**KIRKLEES METROPOLITAN COUNCIL
INVESTMENT & REGENERATION SERVICE**

DELEGATED DECISION TO DETERMINE PLANNING APPLICATIONS

Reference No:	2024/62/90455/W
Site Address:	33, Leaffield Close, Sheepridge, Huddersfield, HD2 1EE
Description:	Erection of single storey rear extension
Recommending Officer:	Tom Hunt

DECISION - REFUSED

Proposed ground floor layout (1:50)

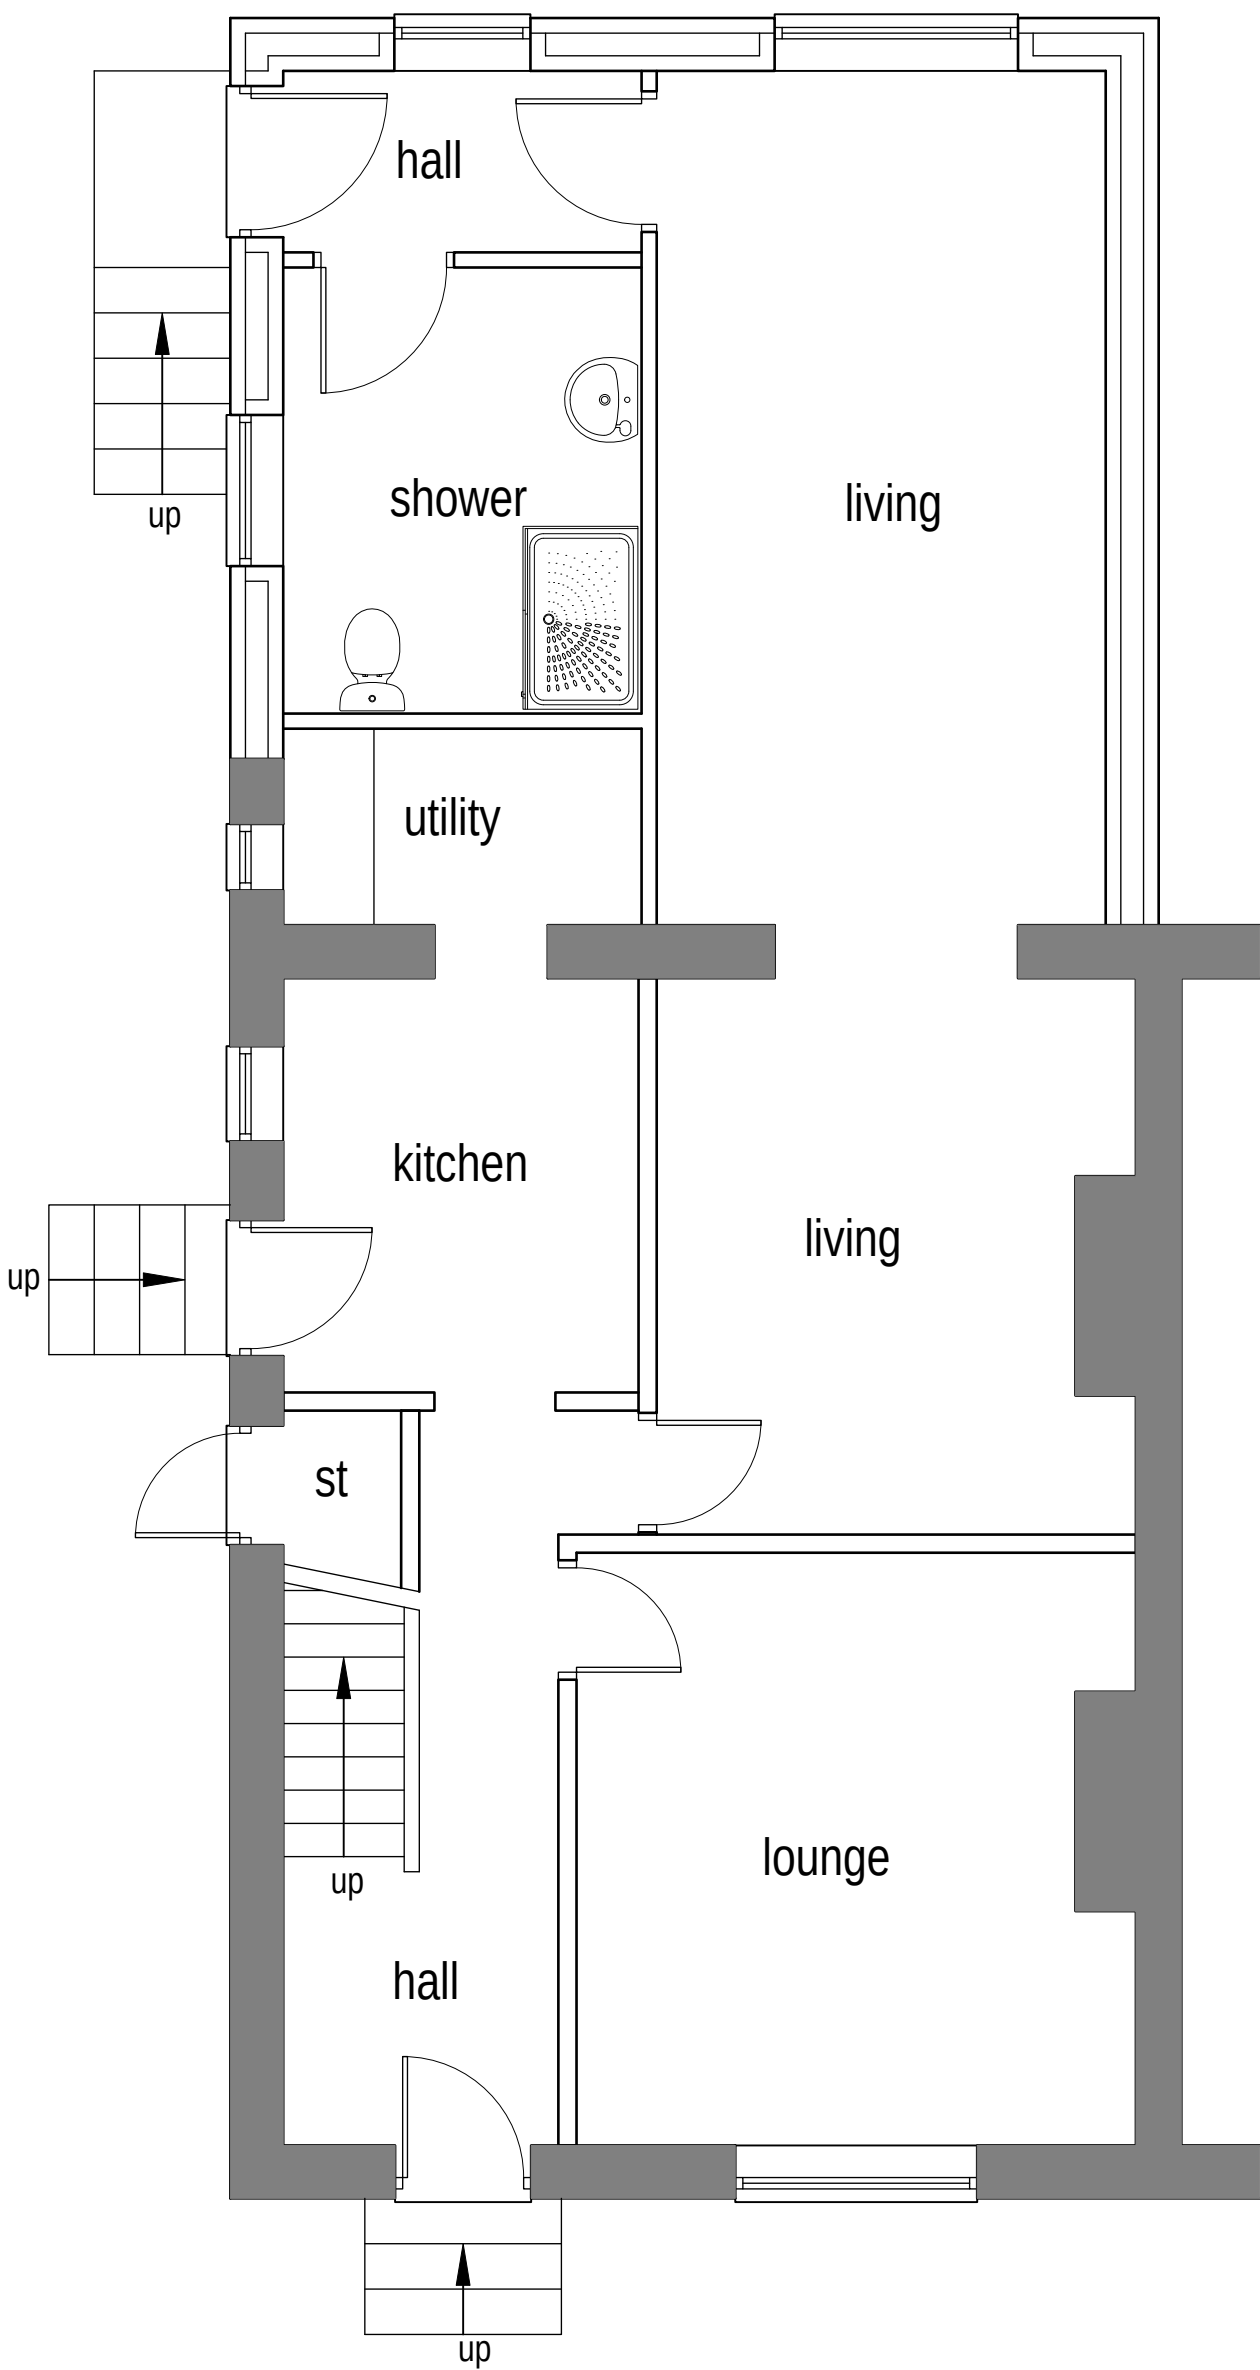
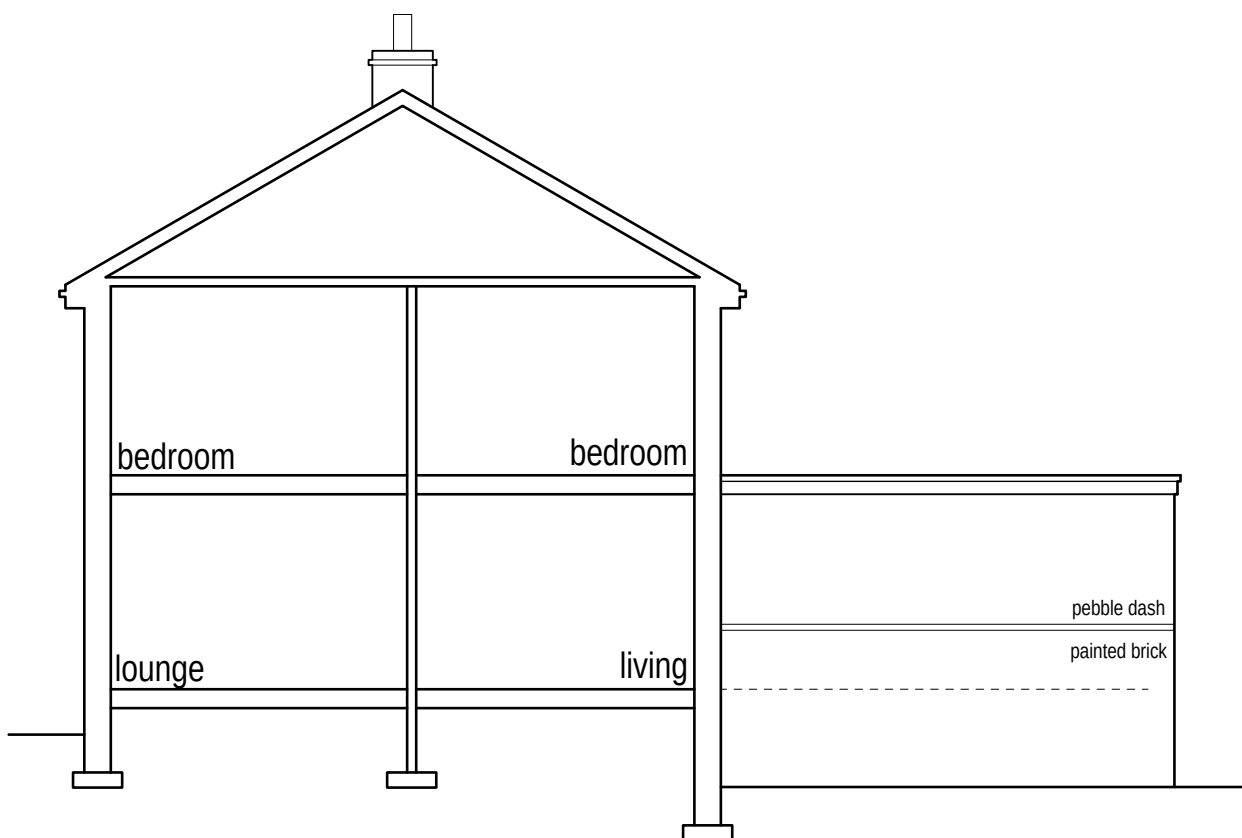
It is proposed to erect a single-storey rear extension with a flat roof, which would be the full span of the host with no separation distance to the shared boundary.

It would be 6m from the rear x 6.2m width and a roof height of 3.9m measured from ground level adjacent to the host with a full height of 4.3m at its rear, given underbuild.

The southeast elevation would be windowless and on the shared boundary of no. 34. There would be openings to the rear and to the northwest side with access enabled by external steps. No railings are indicated.

It would conflict with the advice set out in that it would be 6m exceeding the recommended 3m limit for semi-detached dwellings and would not have a 1m gap to the boundary adjacent to the neighbour. The host is 8.4m depth and the extension would extend more than double this 3m depth presenting a visually overbearing protrusion to the neighbour and a dominant addition to the host. In conjunction with its opposite outrigger, the design without a property gap to boundary would appear to have a tunnelling effect increasing the unwelcome and oppressive impression of overbearing.

As such, the proposal, by virtue of its excessive projection from the rear elevation with no separation distance to the shared boundary with no. 34 to reduce its massing, would not be of a subservient design and would appear as an incongruous and discordant addition to the original dwelling and its

As previously mentioned, the proposal would have a visually overbearing effect to this neighbour, close to the shared boundary with tunnelling. In addition, it would have a significant curtailment of the present 45° field of outlook enjoyed from this neighbour’s adjacent main rear window and would introduce a blank featureless wall which would appear visually dominant. This is the only main ground floor window to the rear of this neighbour so on balance of probabilities it appears to be a habitable window. As such, it would have an unacceptable impact on overbearing to a habitable window.

1. The proposal, by virtue of its excessive projection from the rear elevation with no separation distance to the shared boundary with no. 34 to reduce its massing, would not be of a subservient design and would appear as an incongruous and discordant addition to the original dwelling and its locality. The proposal is therefore contrary to Policies LP02 and LP24 (a and c) of the Kirklees Local Plan, Key Design Principles 1 and 2 of the House Extensions and Alterations SPD and Government Policy contained within Chapter 12 of the National Planning Policy Framework.

1. The proposal would have an unacceptable overbearing impact to the only significant window within the ground floor rear elevation of no. No.34 Leaffield Close. This would have an undue impact on the residential amenity of the occupiers of this property. The proposal is therefore contrary to Policy LP24b) and c) of the Kirklees Local Plan, Key Design Principle 6 of the House Extensions and Alterations SPD and Government guidance contained within Chapter 12 of the National Planning Policy Framework.

The case officer considered the application on review and sought amendments to reduce the impact to the neighbour by limiting the projection to 4m and to have a 1m separation distance to shared boundary. Whilst additional details have been provided, early advice was given to reduce the impact to the neighbour and to enable a development that could adequately achieve a planning balance. This was requested twice (28/02/2024 and 02/05/2024). No response was received so Officers proceeded to determination to ensure that the Decision was issued prior to the end of the Planning Guarantee period.
